CAMPAIGN FOR BETTER TRANSPORT

WRITTEN REPRESENTATION

HIGHWAYS ENGLAND'S RESPONSE

M4 JUNCTION 3-12 SMART MOTORWAY (TR 010019) – SUMMARY OF REPRESENTATIONS MADE AT SPECIAL HEARINGS ON ENVIRONMENT AND SAFETY (WITH ADDITIONAL EVIDENCE)

Figure 1: NO₂ Projections Informing IAN 170/12 v3

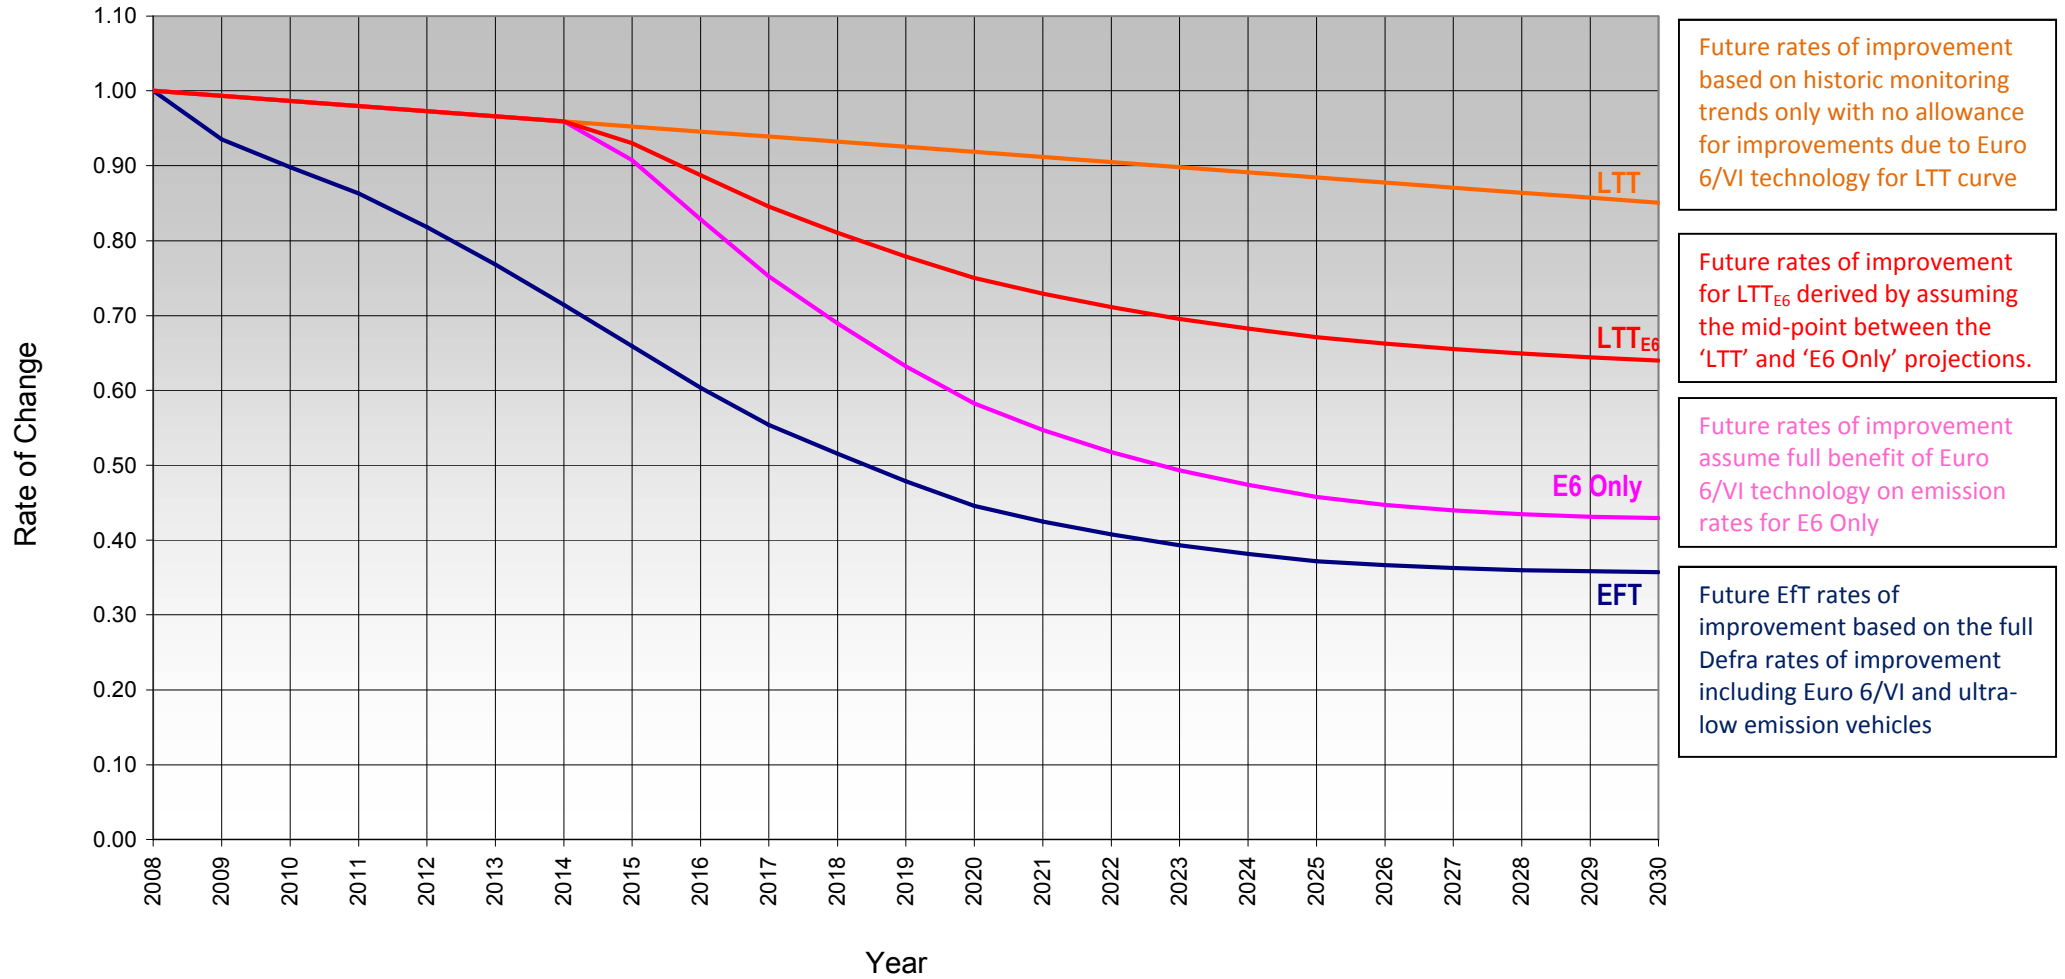
- 2.7 *In addition, the hearing heard from a number of air quality experts who stated that traditionally improvements in air quality had been consistently overestimated and urged caution in future projections. This combination of factors suggests that even if the Highways England profile LTTE6 (on the graph they distributed at the Issue Specific Hearing) is shifted to the right by several years it is still unlikely to accurately reflect real-world emissions. While Highways England described LTTE6 as the realistic 'worst' case they failed to provide any evidence as to why their projection represented an accurate or cautious approach to future trends.*

- 2.8 *However, given that much of the above has happened post the publication of the IAN 170/12 v3, we believe that the most pessimistic future trend (LTT) as shown on the Highways England graph supplied at the Issue Specific Hearing is a sensible and cautious approach to future improvements. It still represents a slight ongoing improvement but does not envisage any sudden improvements as Highways England's graph does.*

- 2.9 *If a robust approach is to be taken to air pollution and for there to be no challenge to any decision, the more pessimistic LTT graph should be used to work out future emissions levels and Highways England should be asked to produce revised data on air pollution.*

2.10.1 The use of the LTT_{E6} projection curve is in recognition of the possibility that air quality is not improving as quickly as envisaged by Defra.

2.10.2 Even considering if Euro 6/VI does not achieve their emission standards they will still be lower than Euro 4/IV and 5/V vehicle emissions. Consequently therefore it is reasonable to assume some level of reduction in emissions in the future and not an almost static trend as described by LTT_{E6}. In adopting the LTT_{E6} approach, Highways England has still allowed for a greater level of uncertainty in future performance to enable the management of risk.

Drawing file: TR010019 / TR010019-003851-Overbridge General Arrangement Sheet 1 Wood Lane.pdf

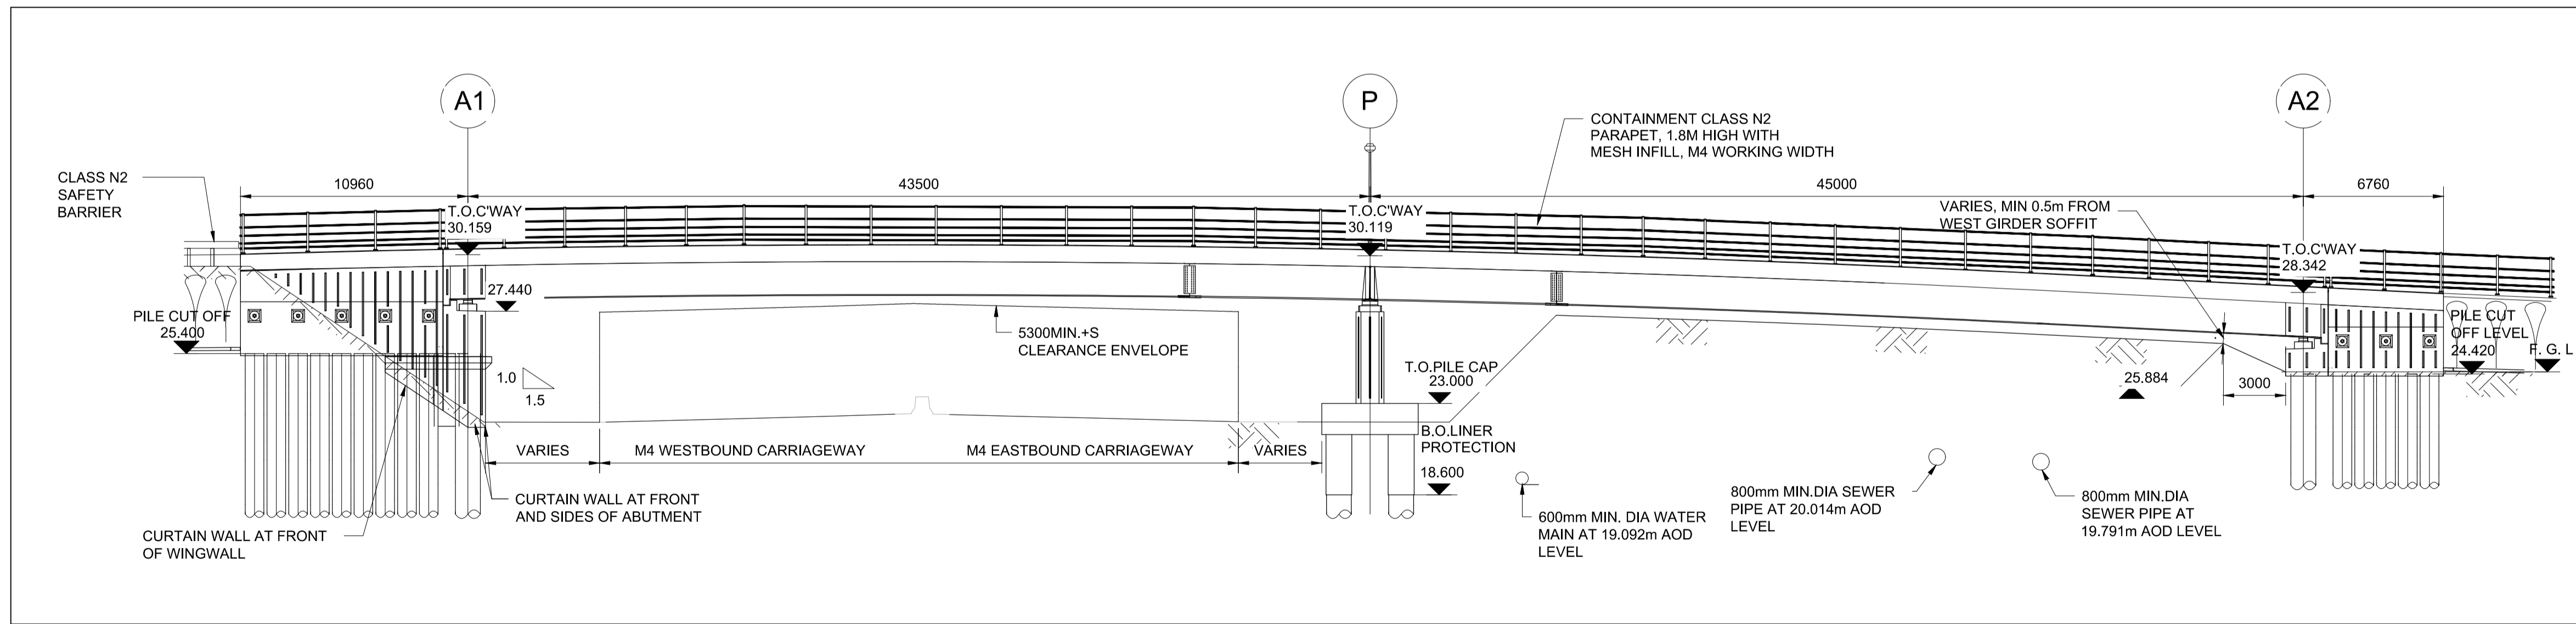
- 3.8 *At a minimum, Highways England should also be looking to provide cycle lanes and safe pedestrian routes on any new bridges it is constructing for busier roads so that these do not present a barrier for future provision. The cost of doing this at construction is much lower than trying to retrofit any such facilities.*

- 3.7.3 The proposed new bridge at Wood Lane includes a 2.0m wide cycle way/foot way along the western side of Wood Lane to accommodate Bridleway Slough 17. The proposed bridge parapets are 1.8m high to provide safe containment of pedestrians, cyclists and equestrian users. Details of the proposed bridge are included in the Bridge General Arrangement Drawings in Annex F2 of the Engineering and Design Report (Application Document Reference 7-4, APP-119).
